Town & Country Planning Act 1990 (as amended) s211 Notice
Application for Prior Notification of Work to Tree(s) in a Conservation Area

Development Various works to various trees within the Main Road/Church Road, Yapton Conservation area.

Location Walnut Tree Cottage Church Road Yapton

LOCATION PLAN

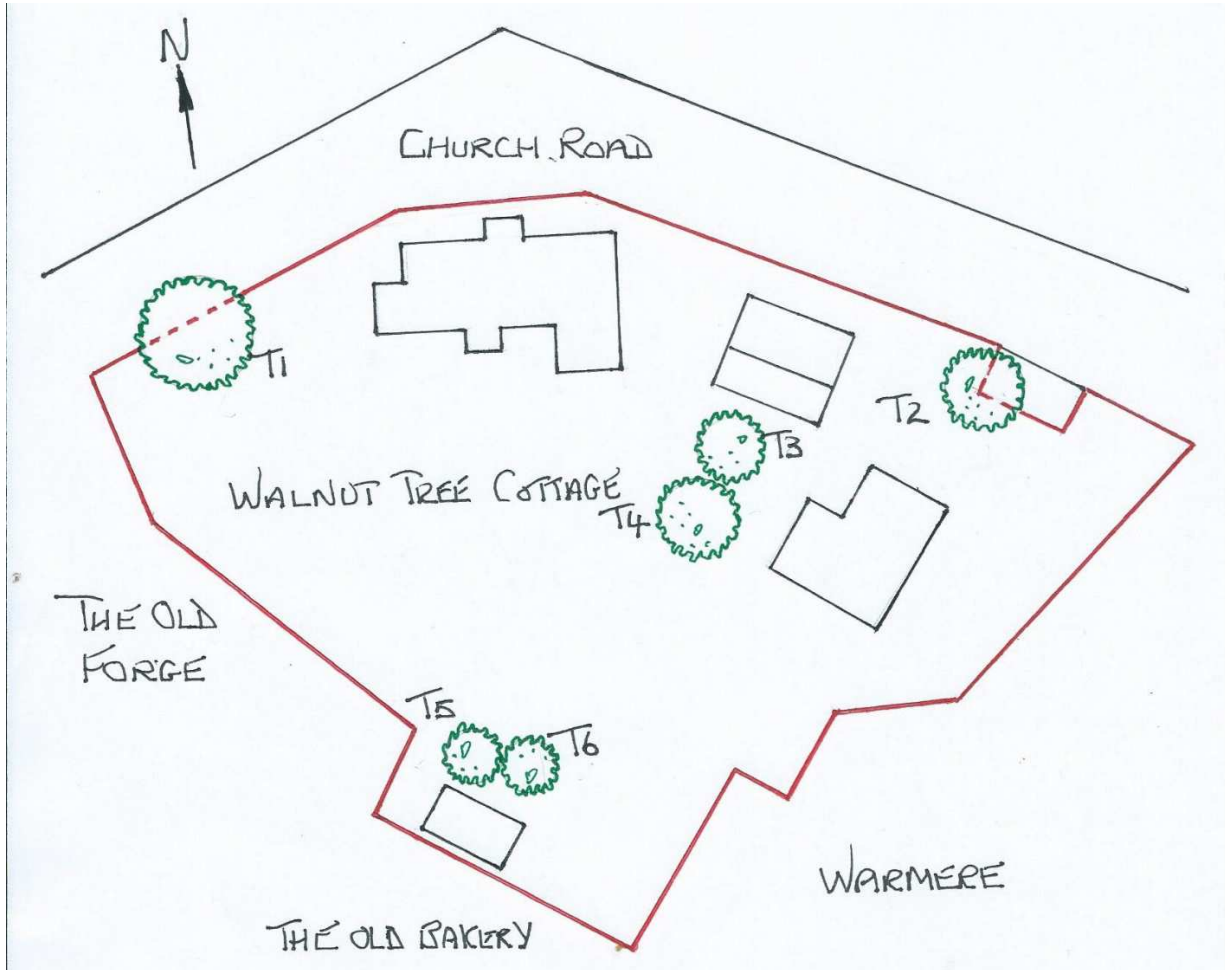
Please clarify the crown reduction measurements in metres after pruning rather than the amount to be removed. Further guidance on this can be found on our website.
